The Planning Inspectorate

Dean Moor Solar Farm – EN010155

Section 51 advice regarding draft application documents

Issued on 29 November 2024

Environmental Statement: Chapter 3 – Figure 3.5 Exclusion Areas

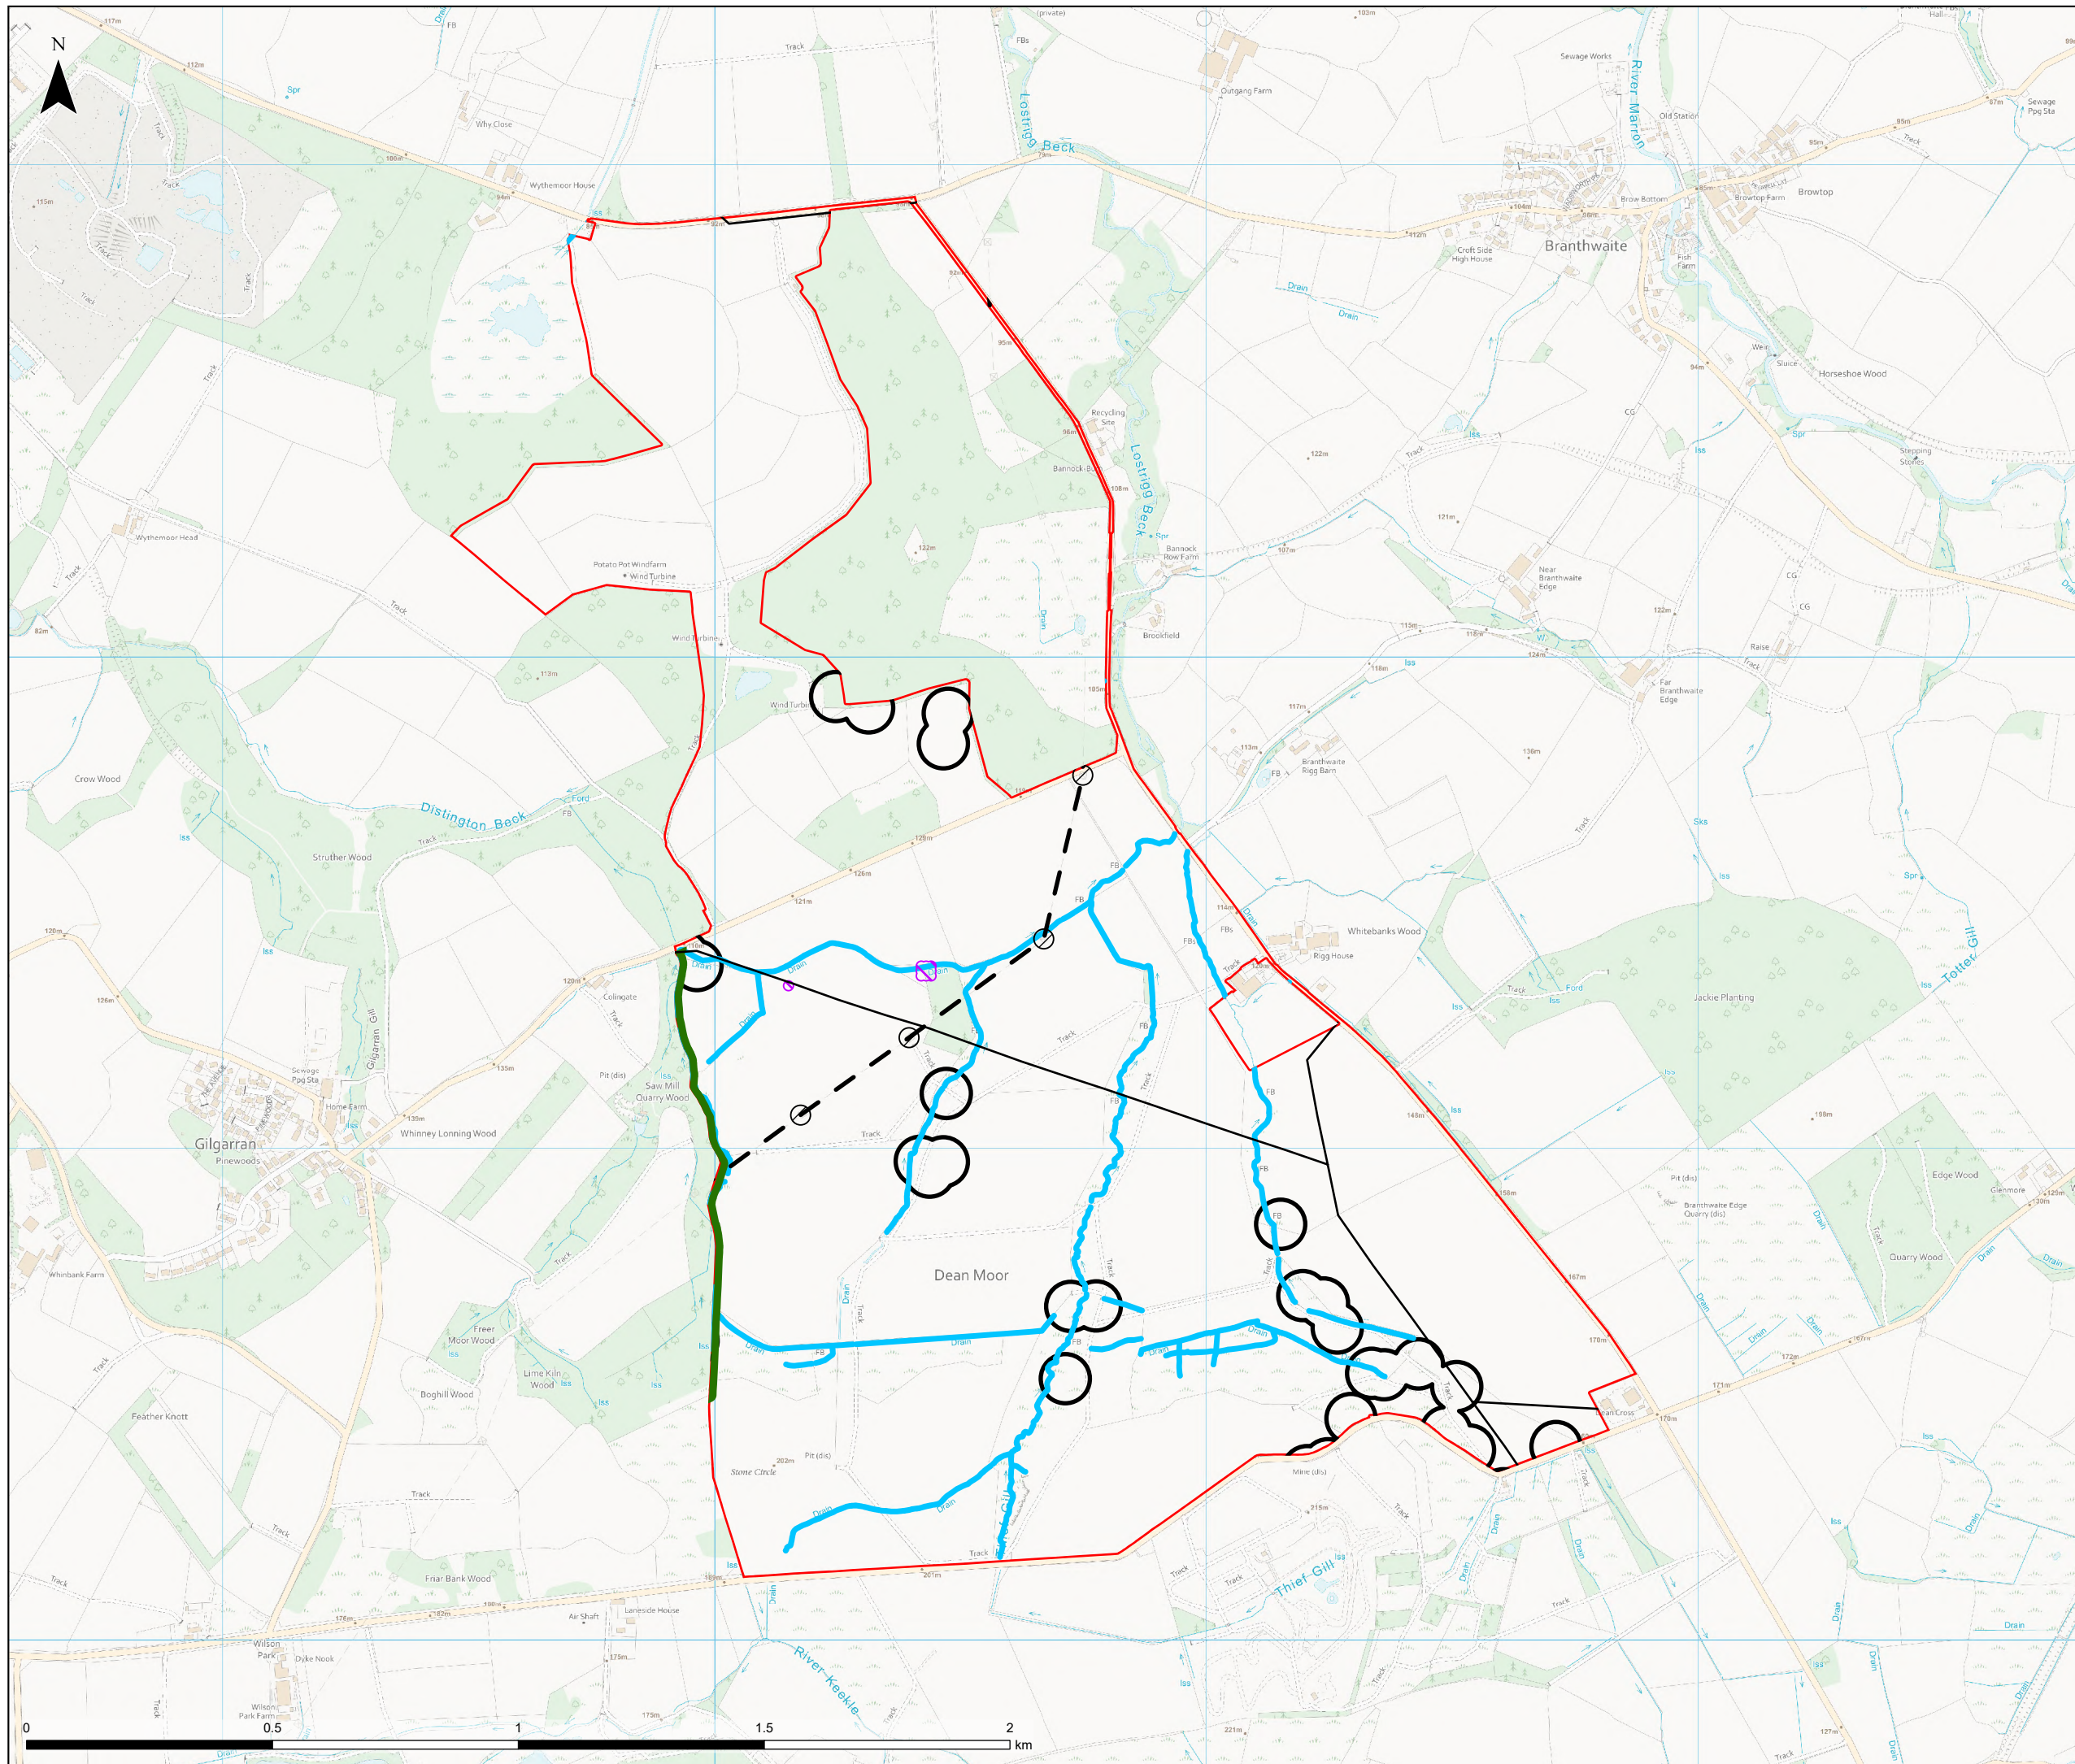
7.	Table 3.3	Table 3.3 sets out exclusion areas. The Applicant is advised to provide a figure to present the various exclusion areas in one location. The Applicant is also advised to indicate with reference to the DCO or other control mechanism, how these exclusion areas have been secured.

LAND PLANS
SHEET 2 OF 4

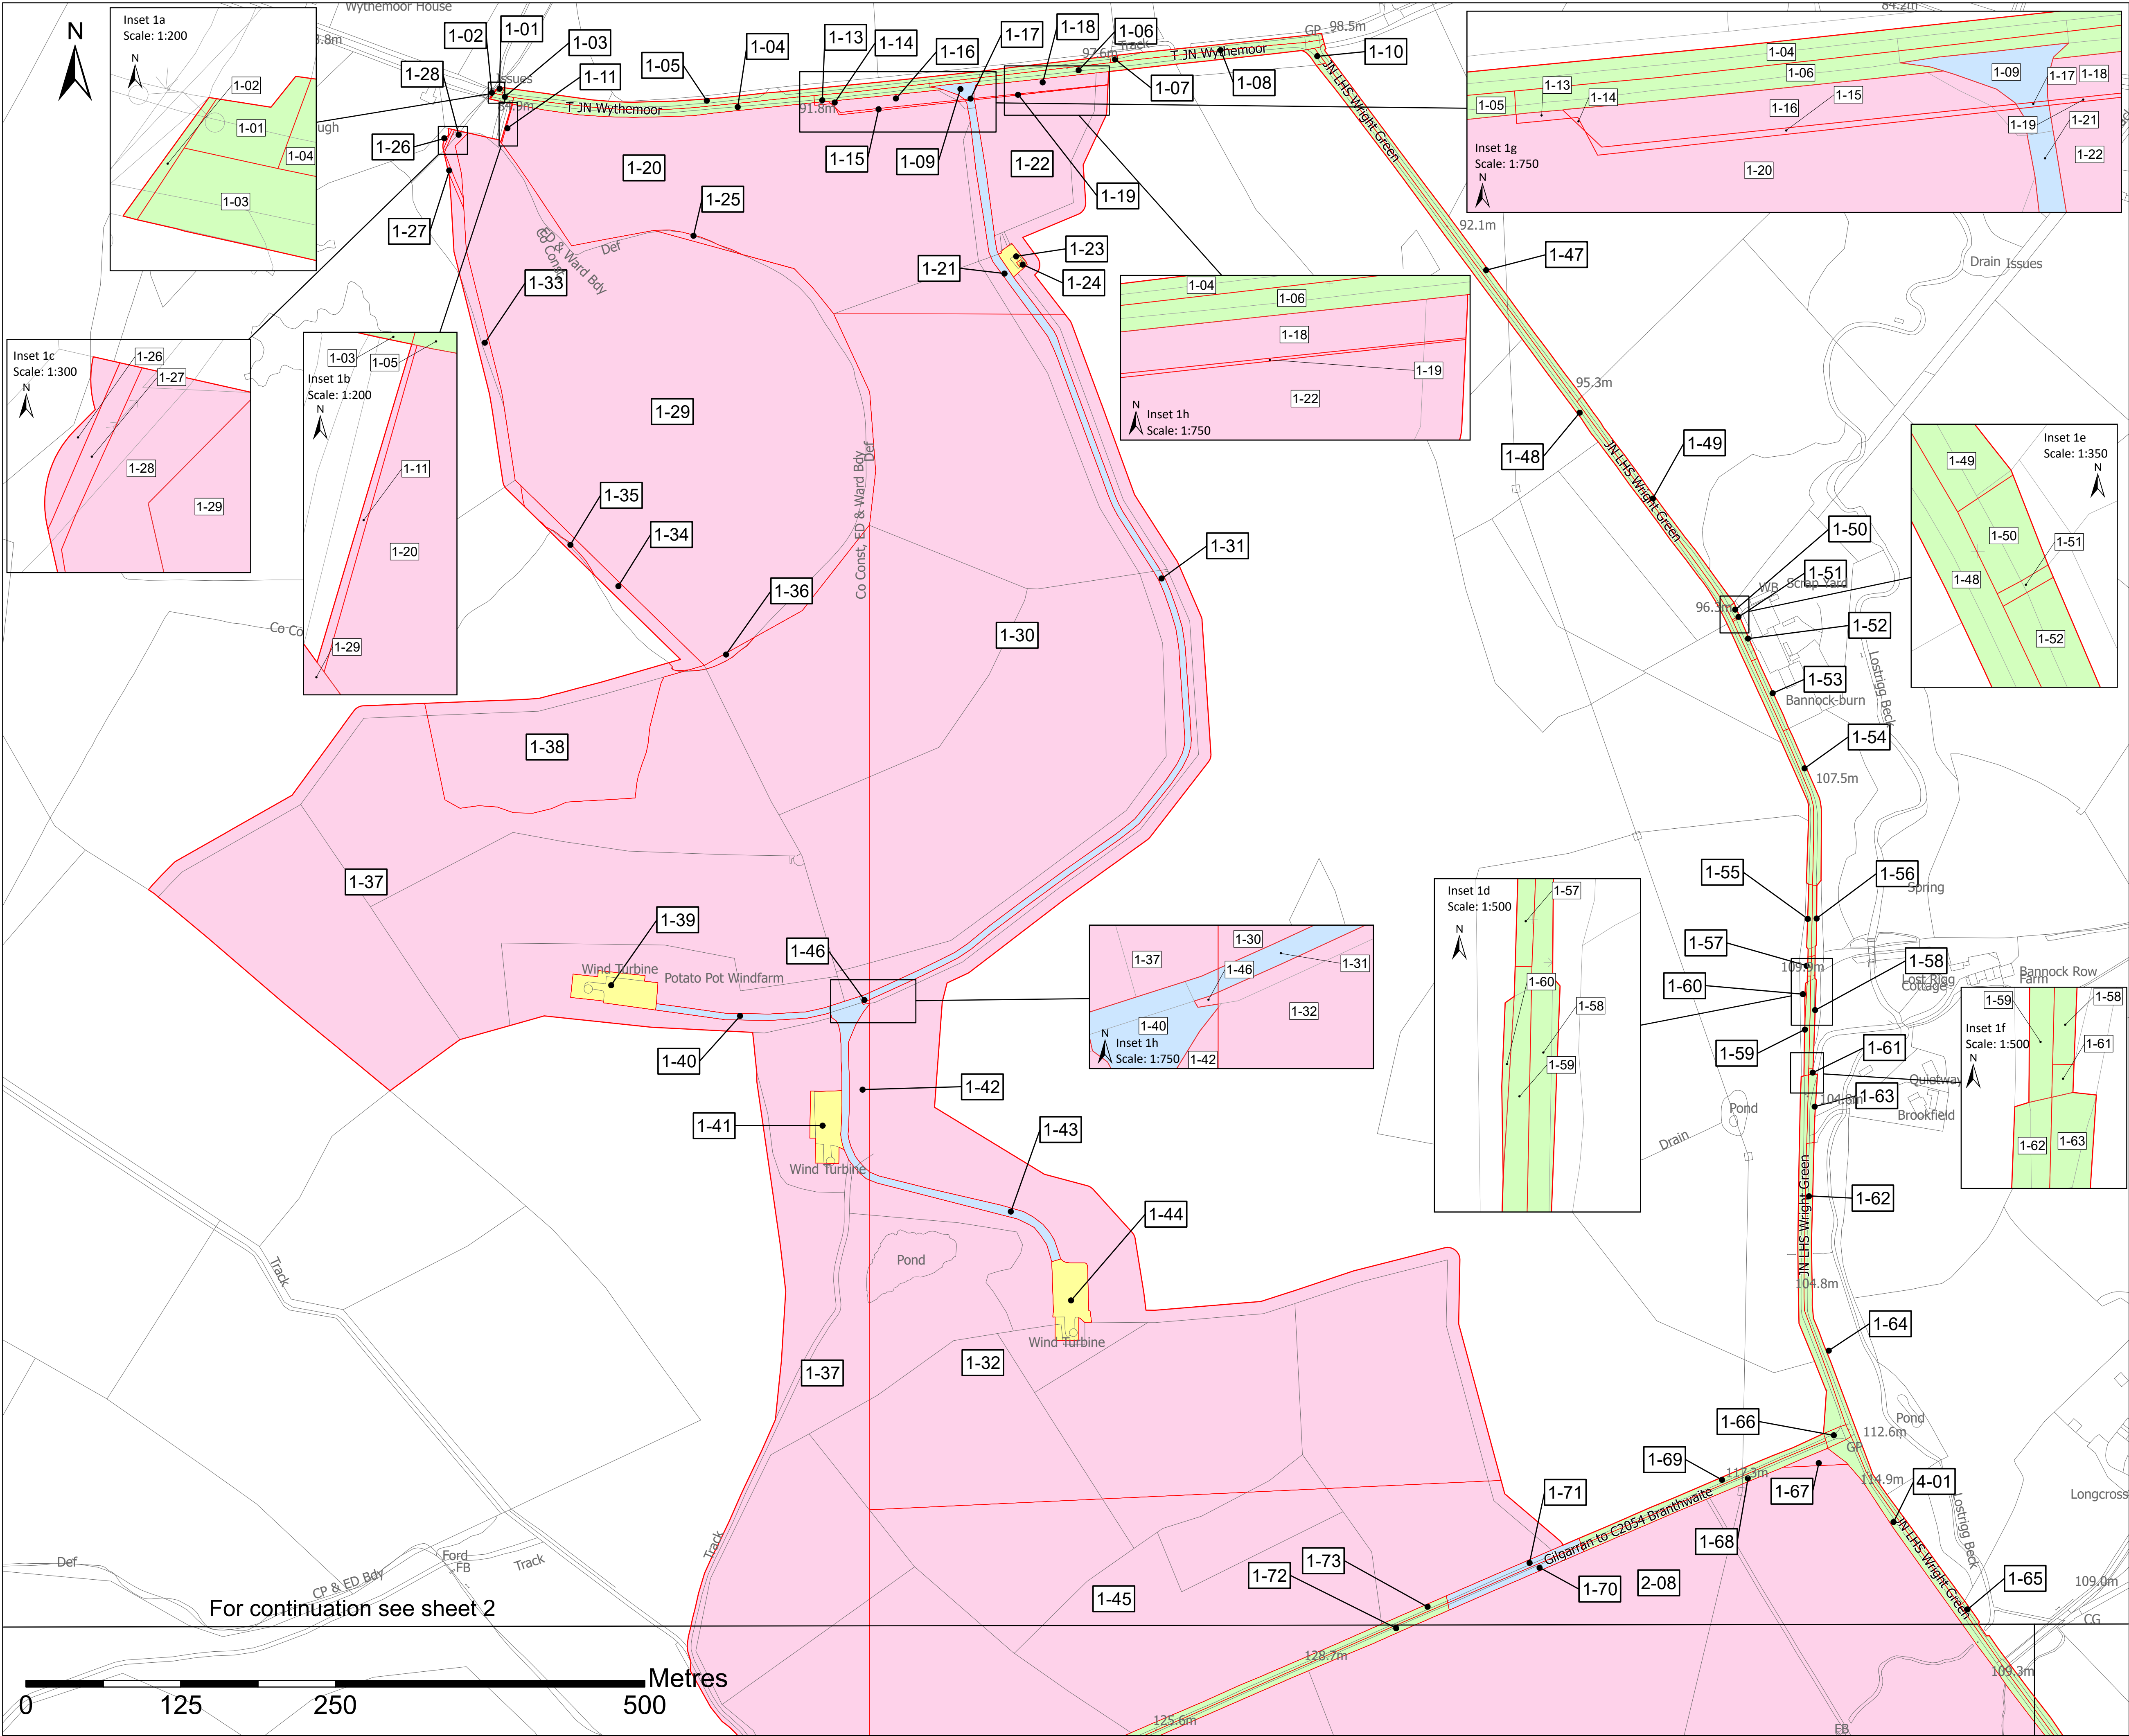
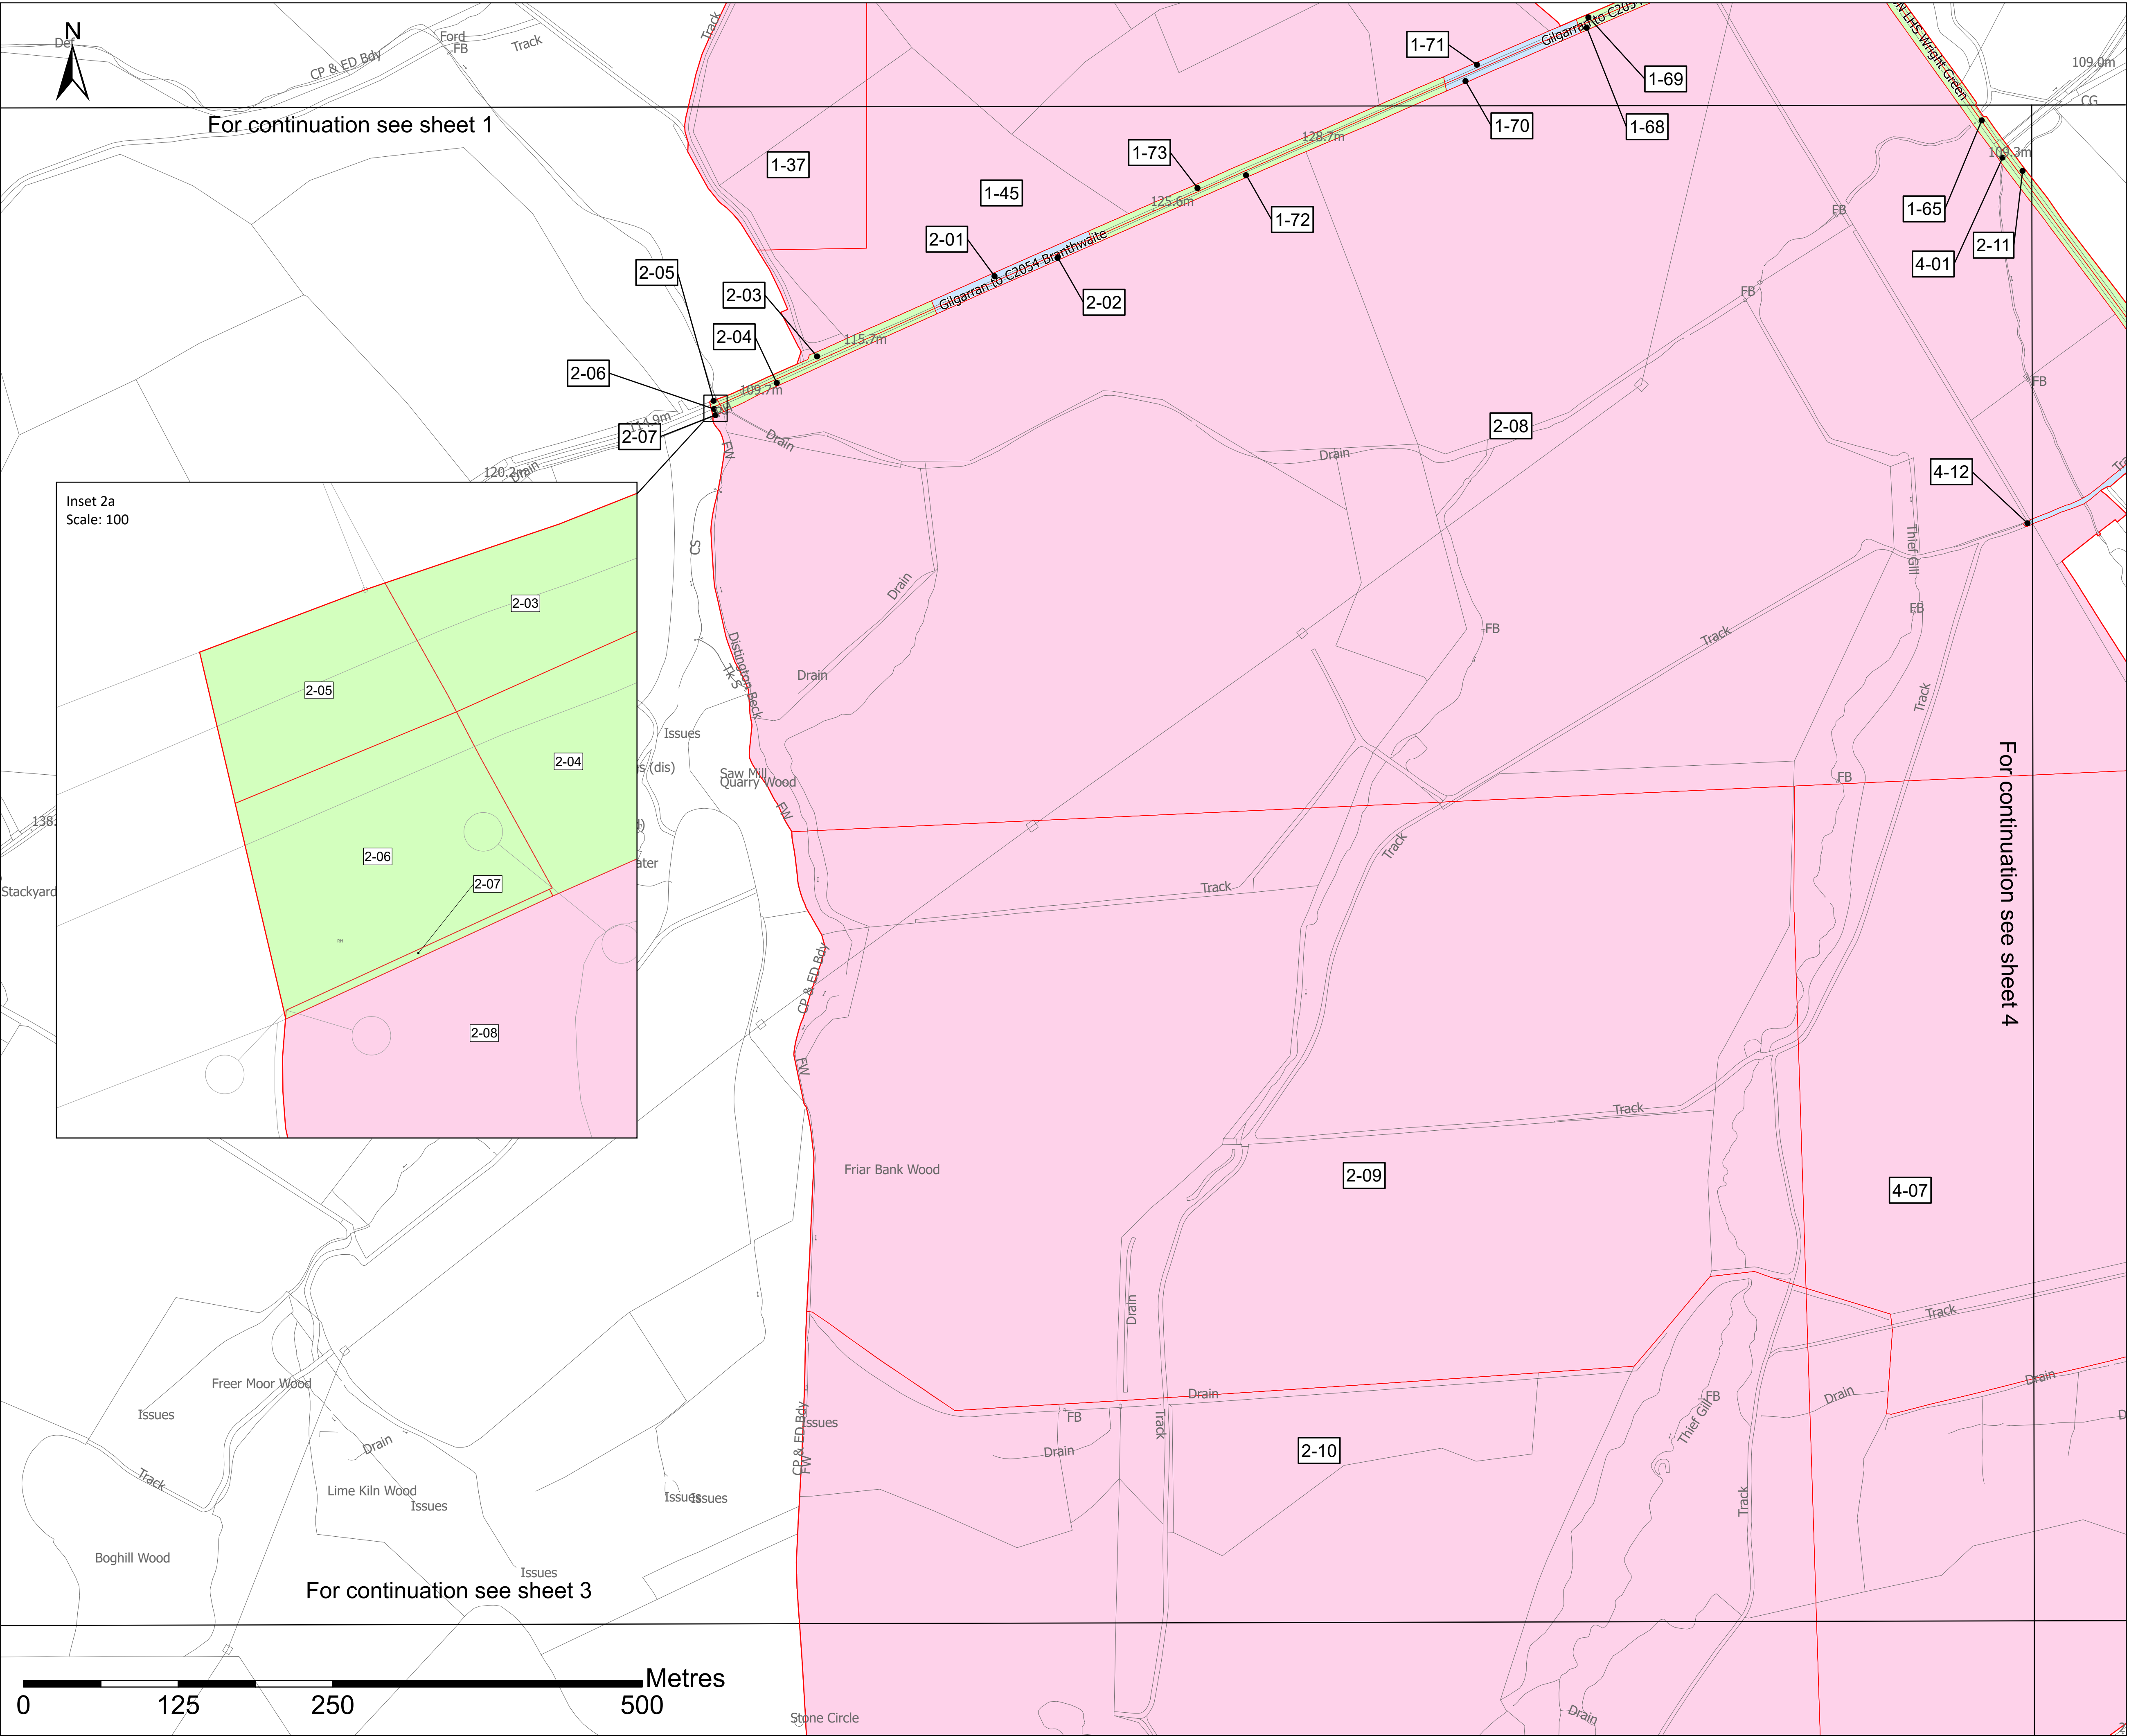
Ref No.	Plan Name and Ref	Comment or question
		The Book of Reference only refers to plots on page 1 of the Land plans map and nothing beyond this; this may be because only a partial draft has been submitted as this stage but please ensure it is complete by submission.
3.	Land Plans (sheet 2)	This seems to show permanent acquisition of public highway (plots 2-01 and 2-02) which may be an error. If it is correct we would expect clarification and justification of this to be included in the application.
